CITY OF ALBUQUERQUE

Planning Department
Alan Varela, Director

September 2, 2022

Re: Broadway Cultivation Facility
1340 Broadway Blvd. NE
Traffic Circulation Layout
Architect's Stamp 06-15-22 (J14-D202)

SHEET TITLE:
TRAFFIC
CIRCULATION
PLAN

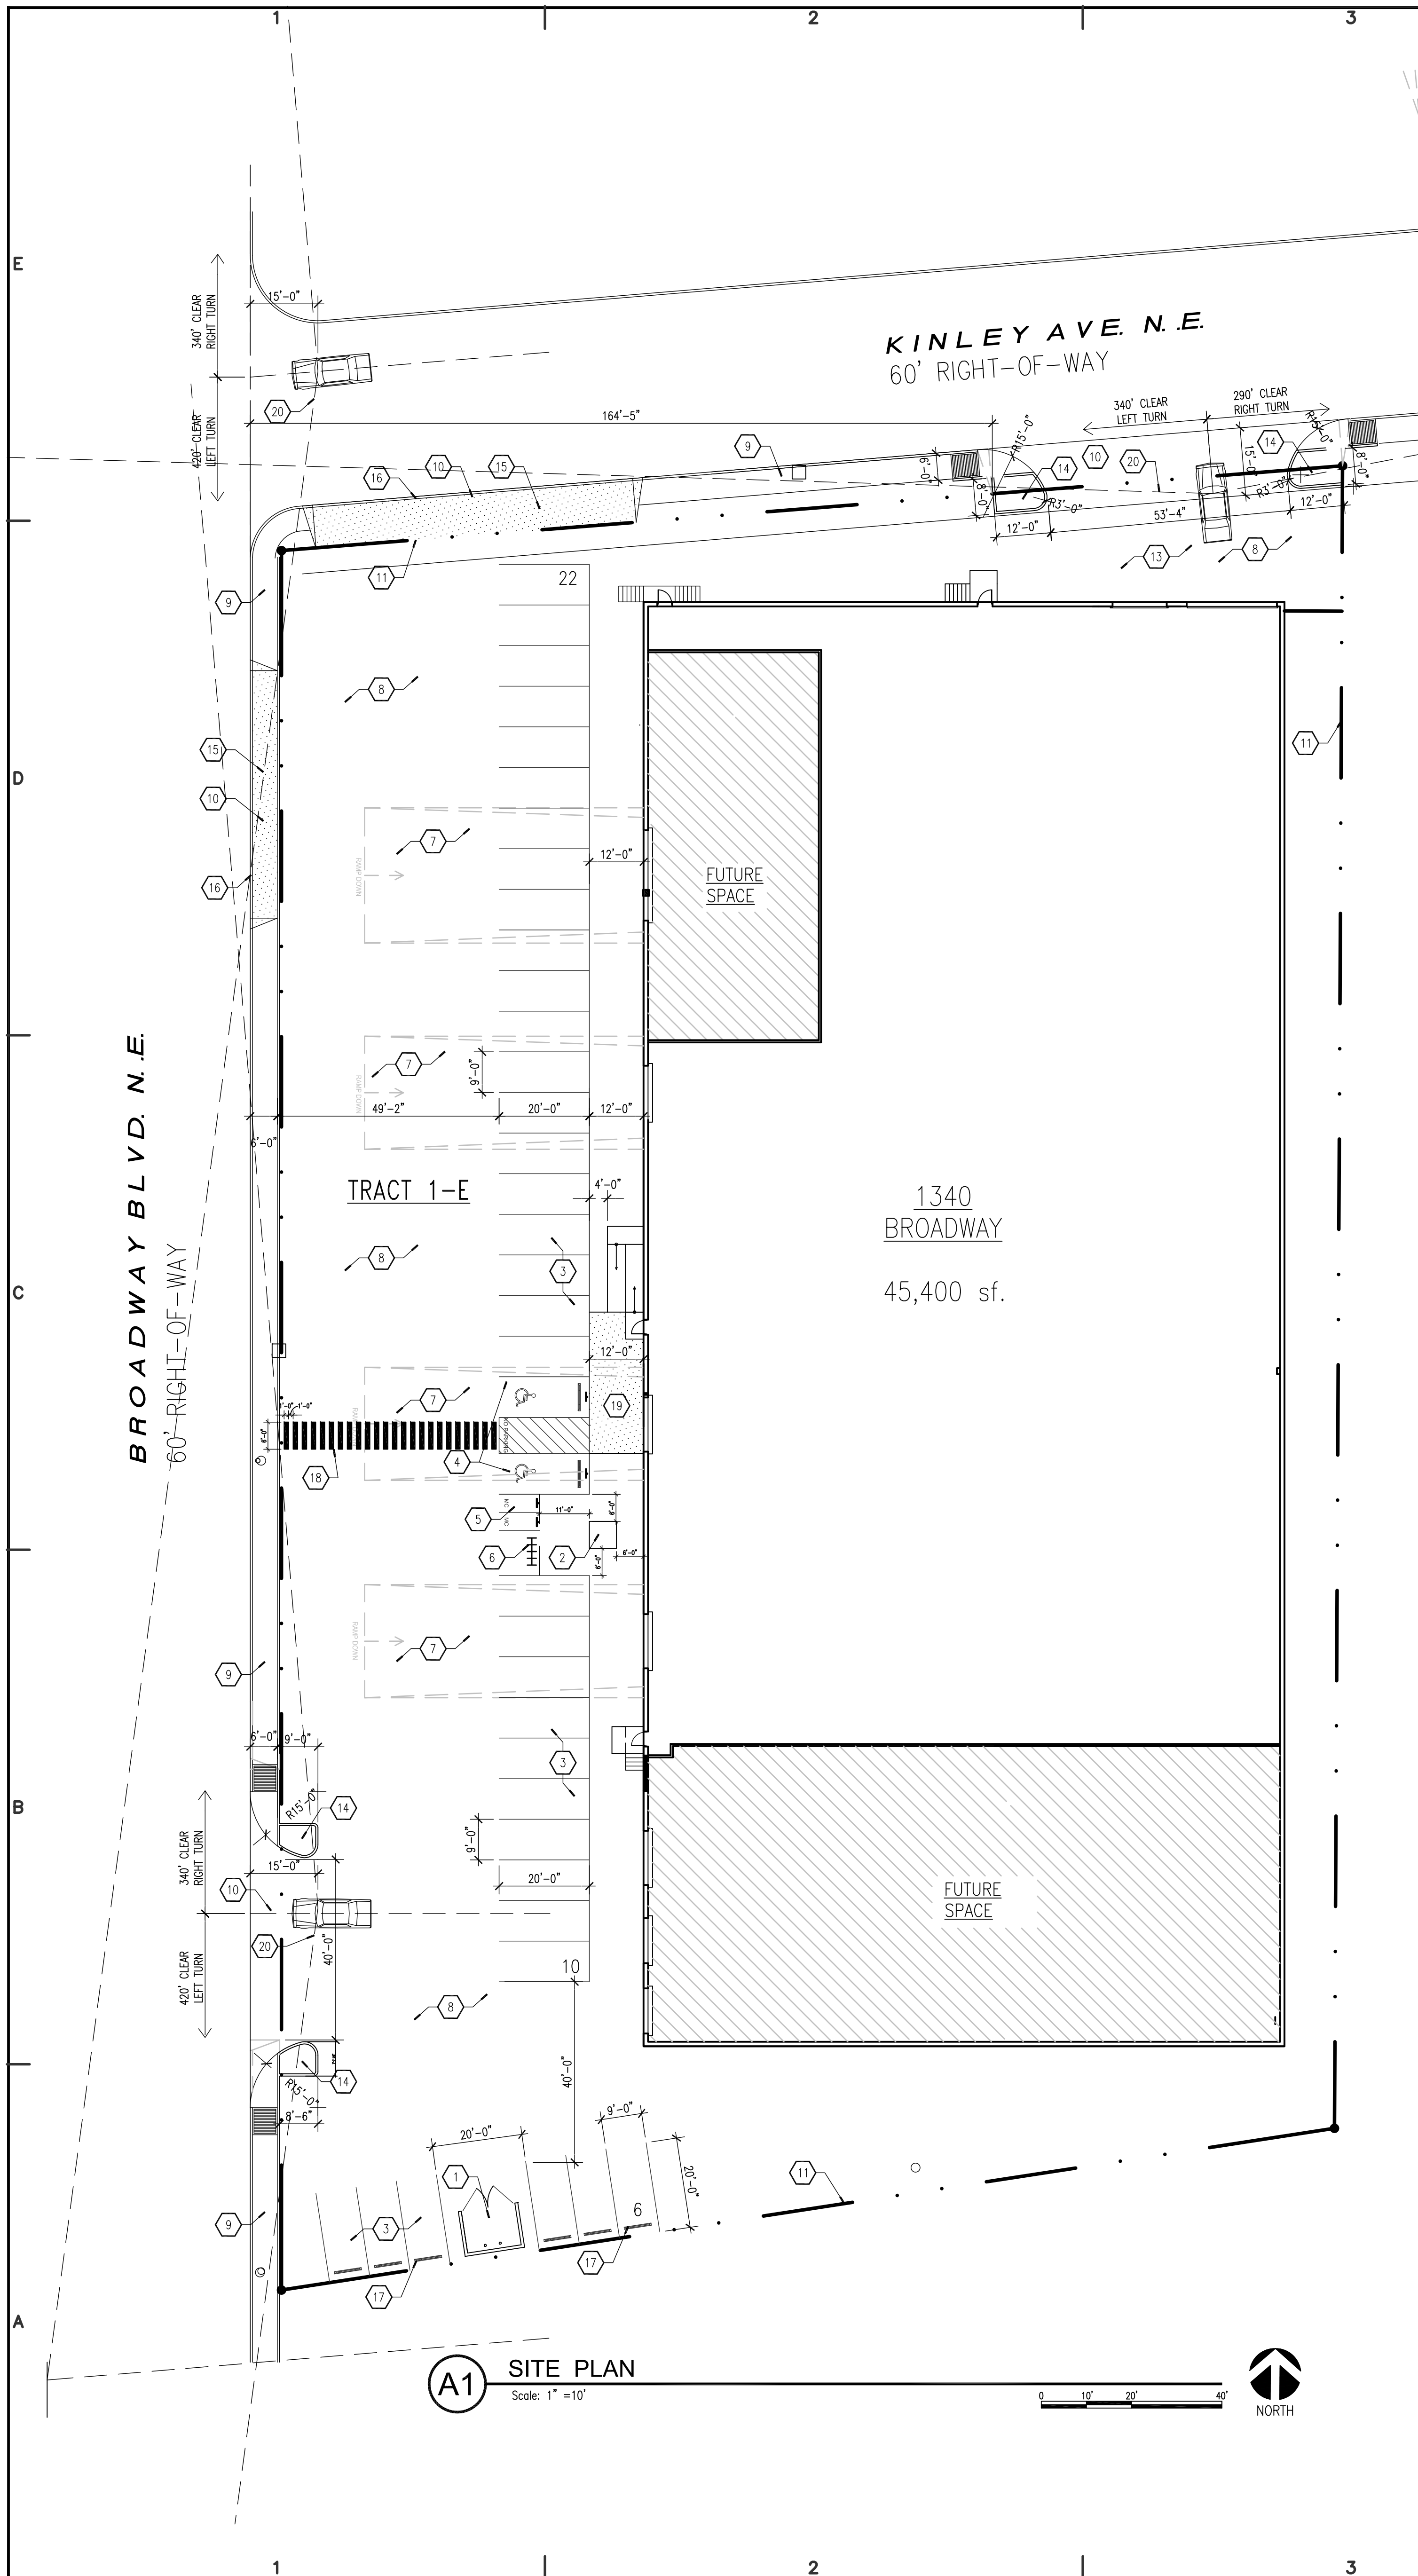
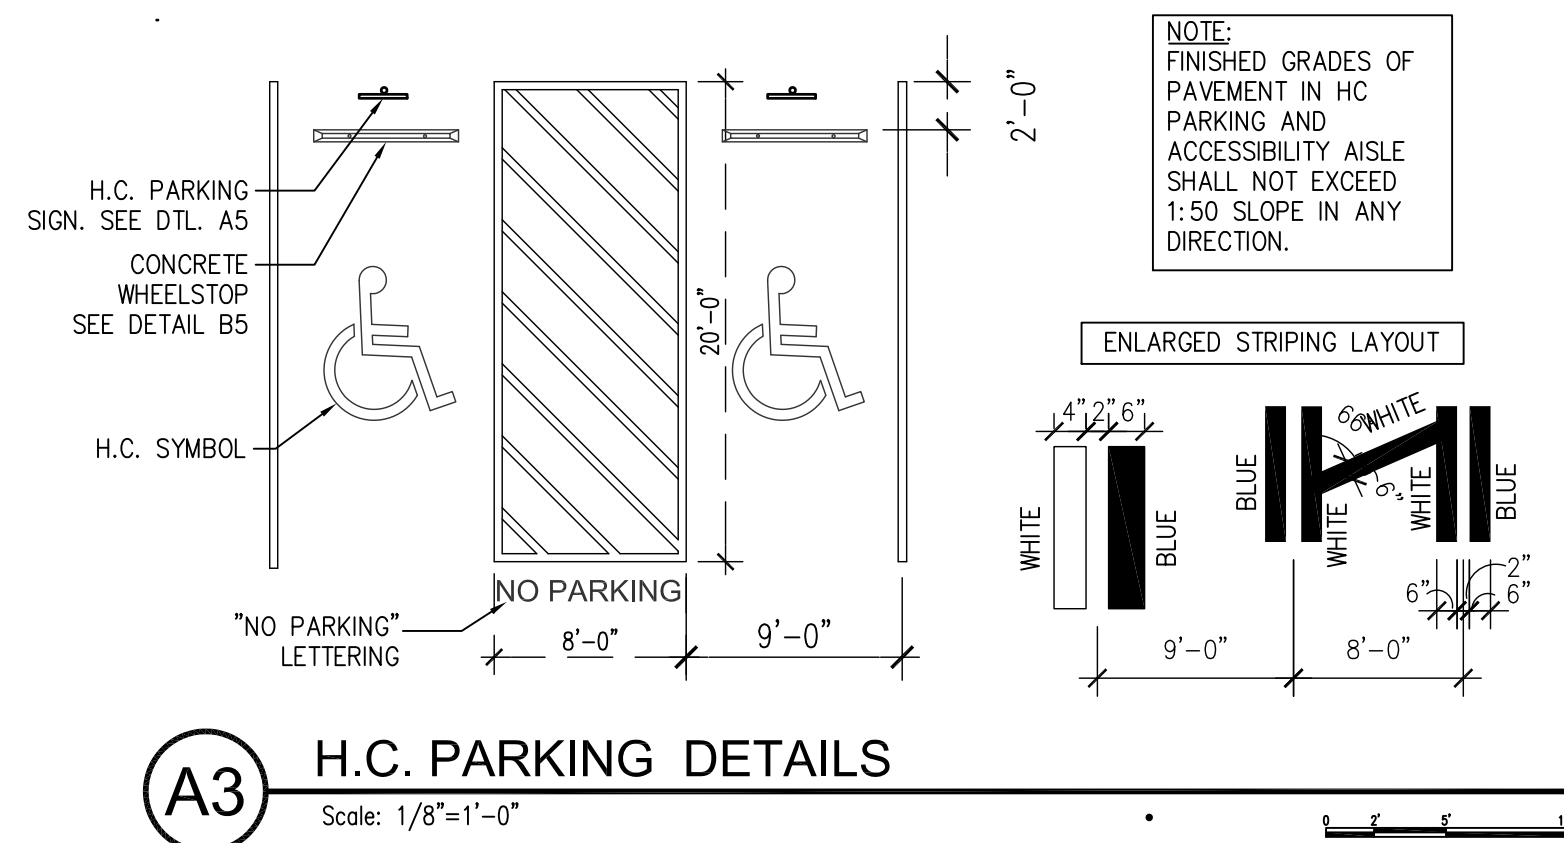
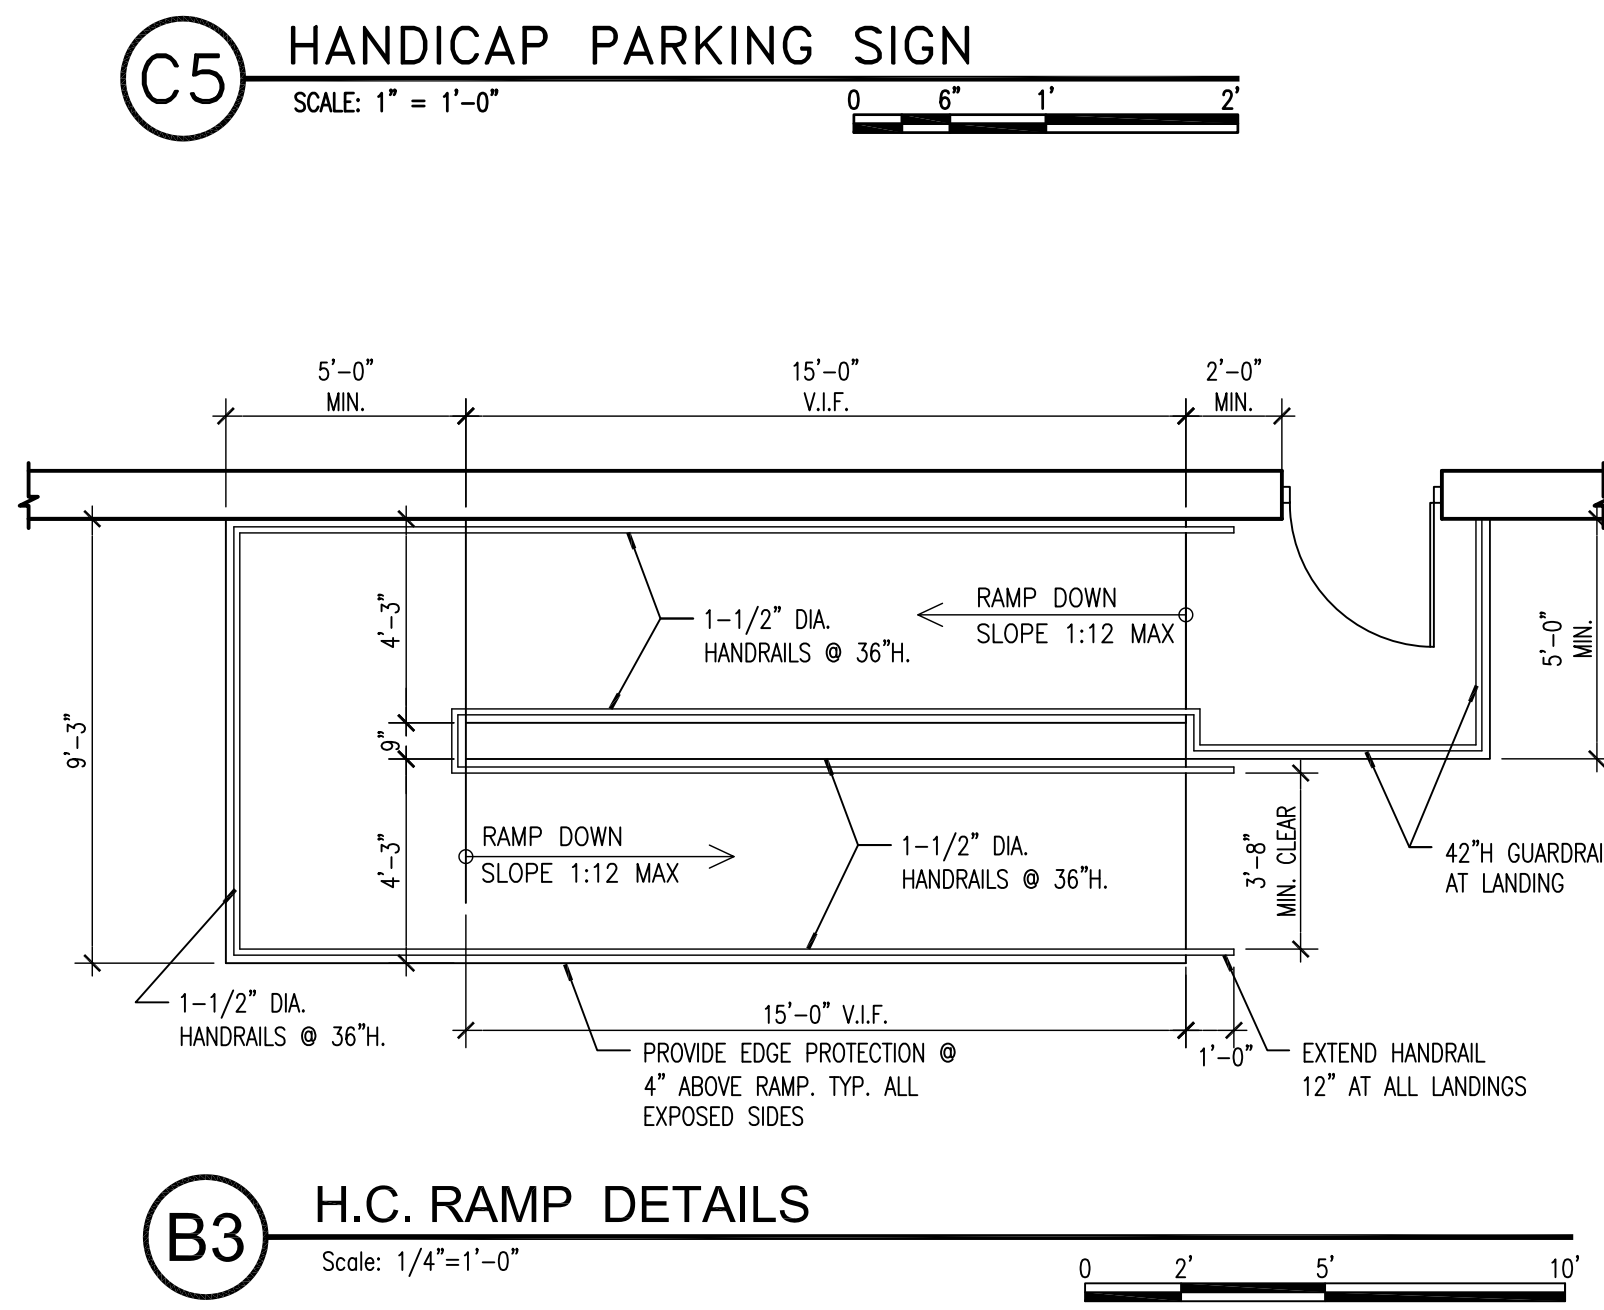
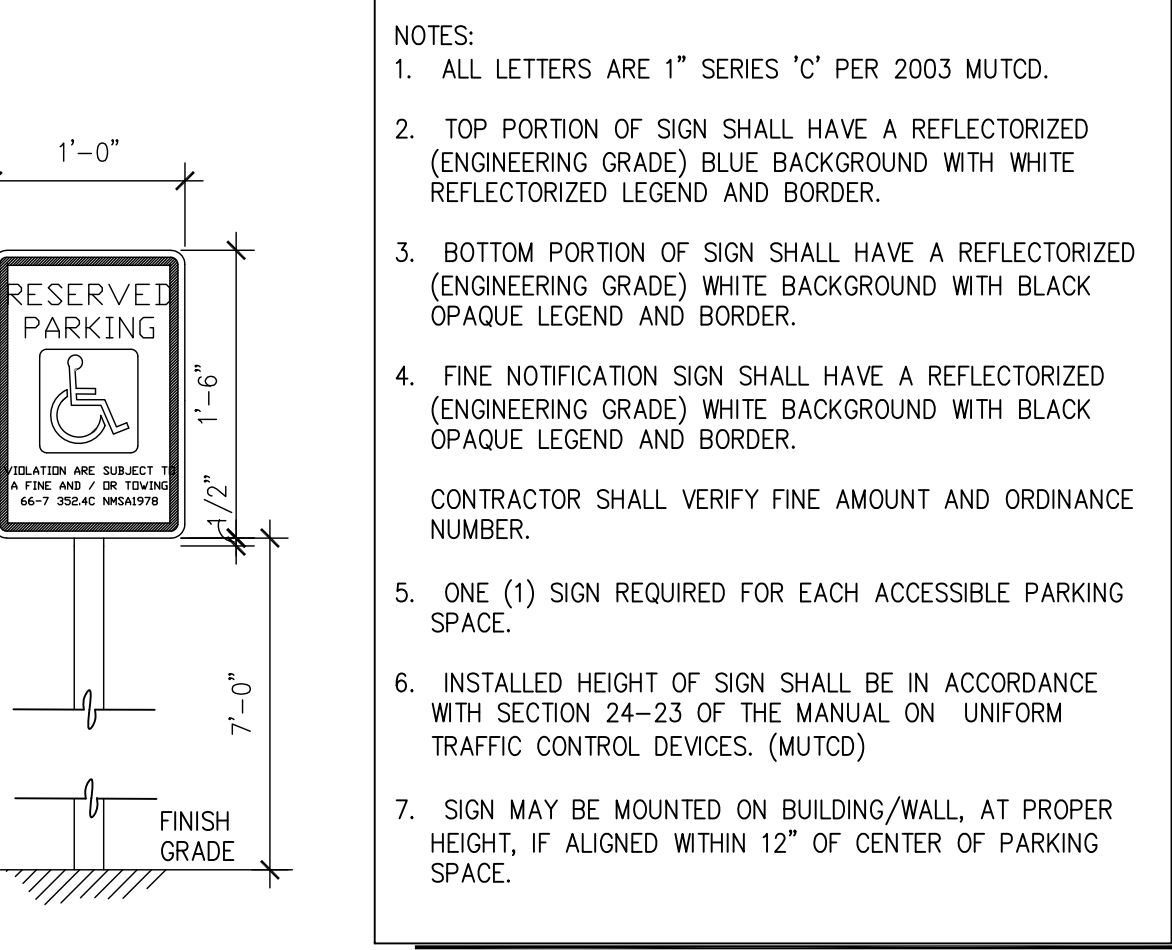
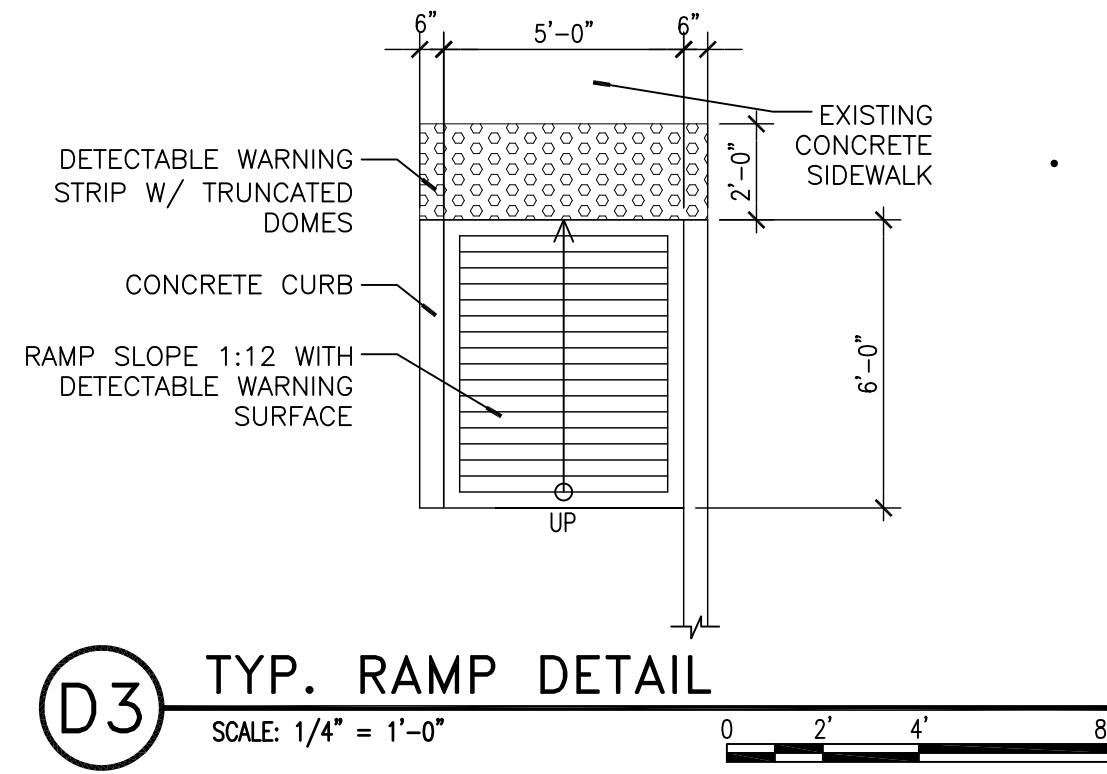
1. Please see attached Minimum Distance from Commercial Site Access Points to the Intersection. Also, note that Broadway Blvd. is classified as Principal Arterial, and Kinley Ave. classified as Local St.
2. Curb Return Access design need to provided.
3. Maximum access width for arterial, collector, and local streets are as follows:

4. Please list the width and length for all existing and proposed parking spaces. Some dimensions are not shown.
5. The minimum parking stall dimensions are:

6. ADA Ramp at the corner of Broadway Blvd. and Kinley Ave. need to be updated to current COA standard.
7. ADA curb ramps must be updated to current standards and have truncated domes installed.

8. Motorcycle parking spaces shall be designated by its own conspicuously posted upright sign, either free-standing or wall mounted per the zoning code. Please provide signs details.

9. The pavement marking "MC" should be shown in the opposite direction for motorcycles entering the parking space.
10. All bicycle racks shall be designed according to the following guidelines:

11. Bicycle racks shall be sturdy and anchored to a concrete pad.
12. A 1-foot clear zone around the bicycle parking stall shall be provided.
13. Bicycle parking spaces shall be at least 6 feet long and 2 feet wide.

14. Per the IDO, a 6 ft. wide ADA accessible pedestrian pathway is required from the public sidewalk to the building entrances. Please clearly show this pathway and provide details.

15. Per DPM, a 6 ft. wide ADA accessible pedestrian pathway is required from the ADA parking stall access aisles to the building entrances. Please clearly show this pathway and provide details.

17. Parking areas shall have barriers to prevent vehicles from extending over public sidewalk, public right-of-way, or abutting lots. Provide details for the barriers curb.

19. Please provide a sight distance exhibit
20. Show the clear Intersection sight distance and add the following note to the plan:
"Landscaping and signage will not interfere with clear sight requirements. Therefore,

signs, walls, trees, and shrubbery between 3 and 8 feet tall (as measured from the gutter pan) will not be acceptable in the clear sight triangle. See attached

21. Please specify the City Standard Drawing Number when applicable.
22. Unused curb cuts must be replaced with sidewalk and curb & gutter. A build note must be provided referring to the appropriate City Standard drawing.
23. Add a note stating "All broken or cracked sidewalk must be replaced with sidewalk and curb & gutter." A build note must be provided referring to the appropriate City Standard drawing.
24. Please provide a letter of response for all comments given.
25. Traffic Studies: See the Traffic Impact Study (TIS) thresholds. In general, a minimum combination of 100 vehicles entering and exiting in the peak hour warrants a Traffic Impact Study. Visit with Traffic Engineer for determination, and fill out a TIS Form that states whether one is warranted. In some cases, a trip generation may be requested for determination (**Contact Matt Grush: mgrush@cabq.gov**).
